**MASTER BLASTER**  
GBP LOT 35-2  
1254 COLE VIEW  
COLORADO SPRINGS, CO 80915  
EL PASO COUNTY, COLORADO

1 of 8  
SITE PLAN

PPR-17-056

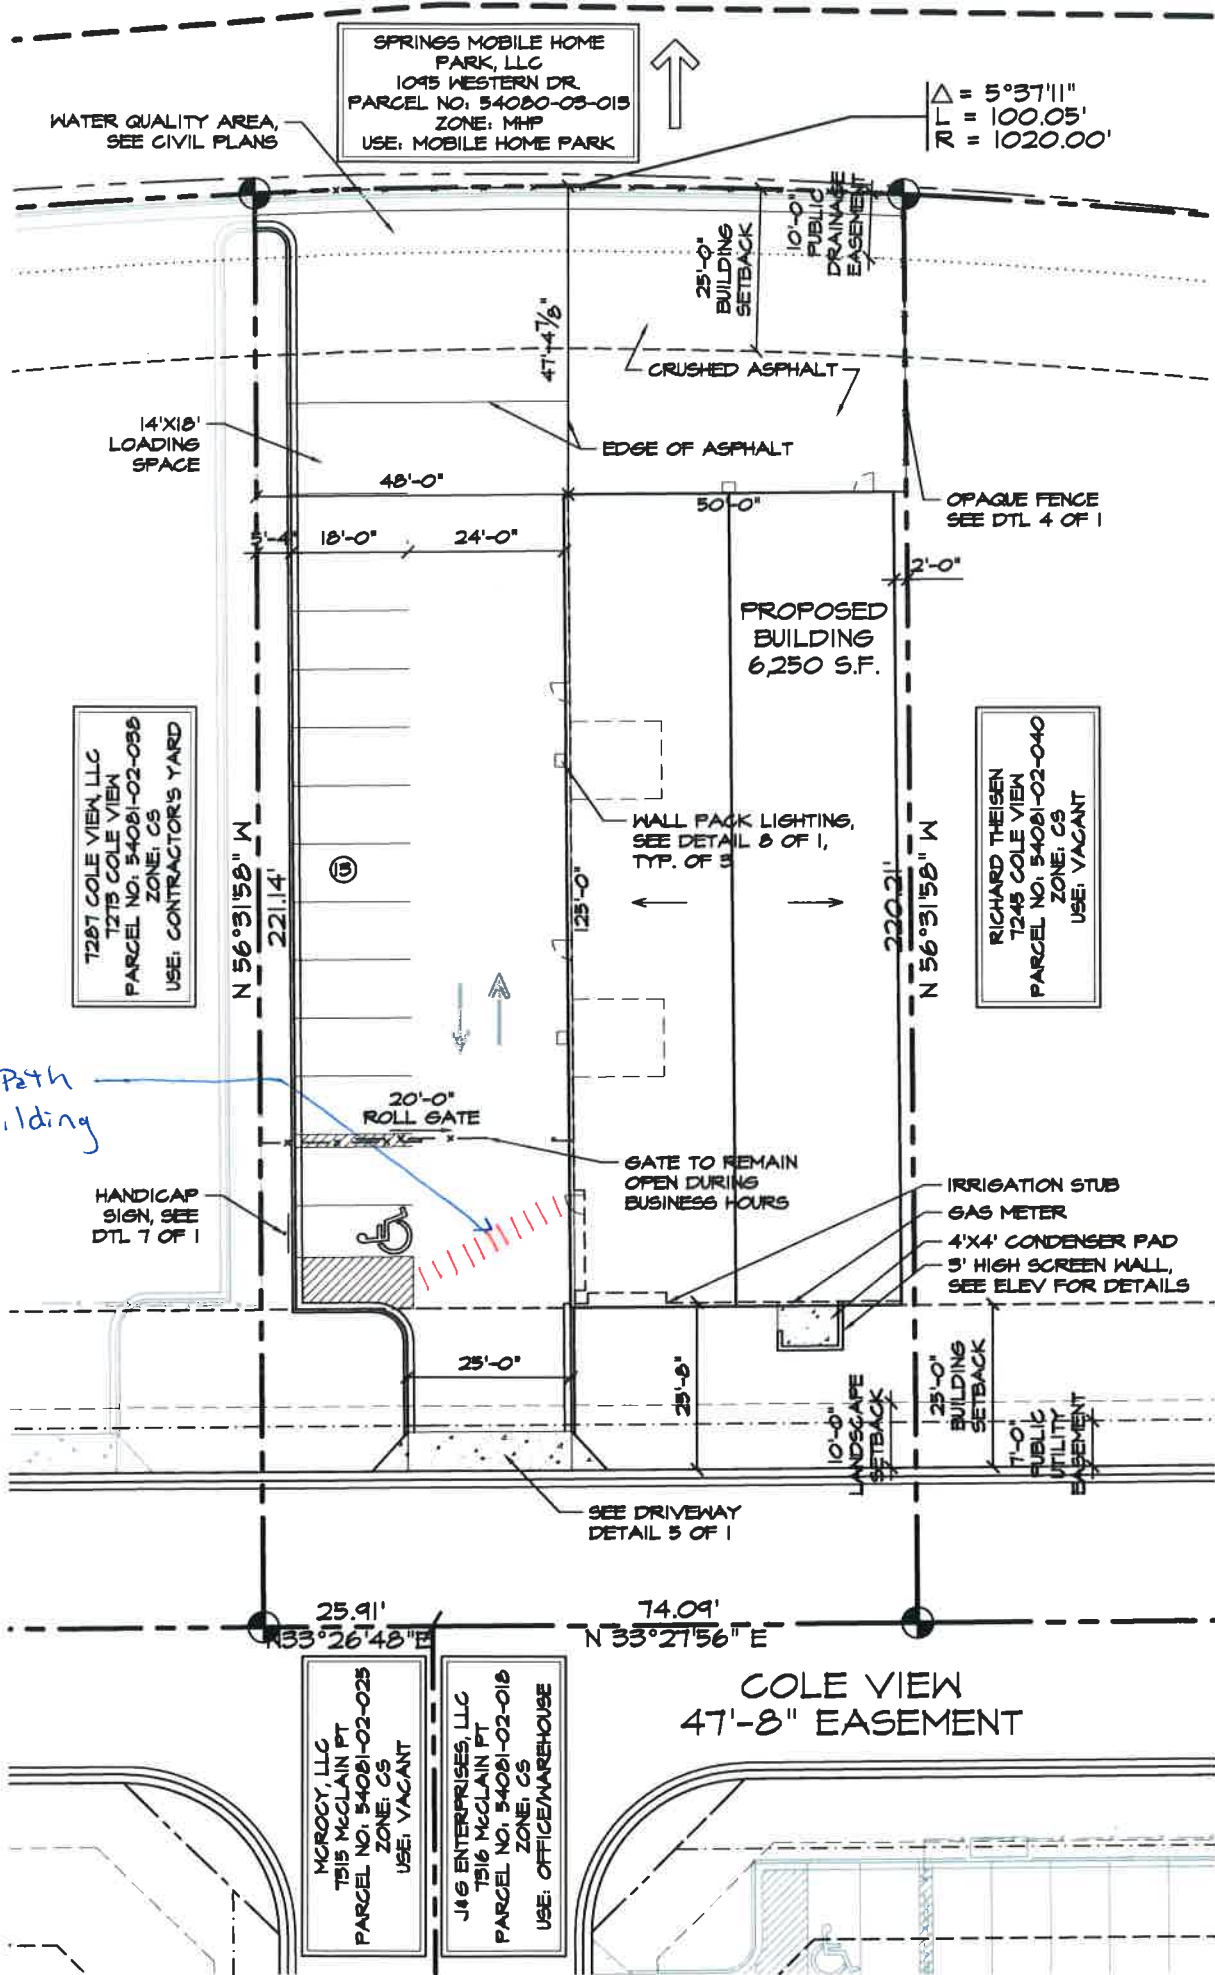
Per the LDC revisions approved 12/12/17 we require the ADA route to be shown on the plans (can be separate page) and the following note added:

The parties responsible for this plan have familiarized themselves with all current accessibility criteria and specifications and the proposed plan reflects all site elements required by the applicable ADA design standards and guidelines as published by the United States Department of Justice. Approval of this plan by El Paso County does not assure compliance with the ADA or any regulations or guidelines enacted or promulgated under or with respect to such laws.

Please confirm there will be no outside storage.

The use does not appear to be warehousing. The parking calculations may need to be amended.
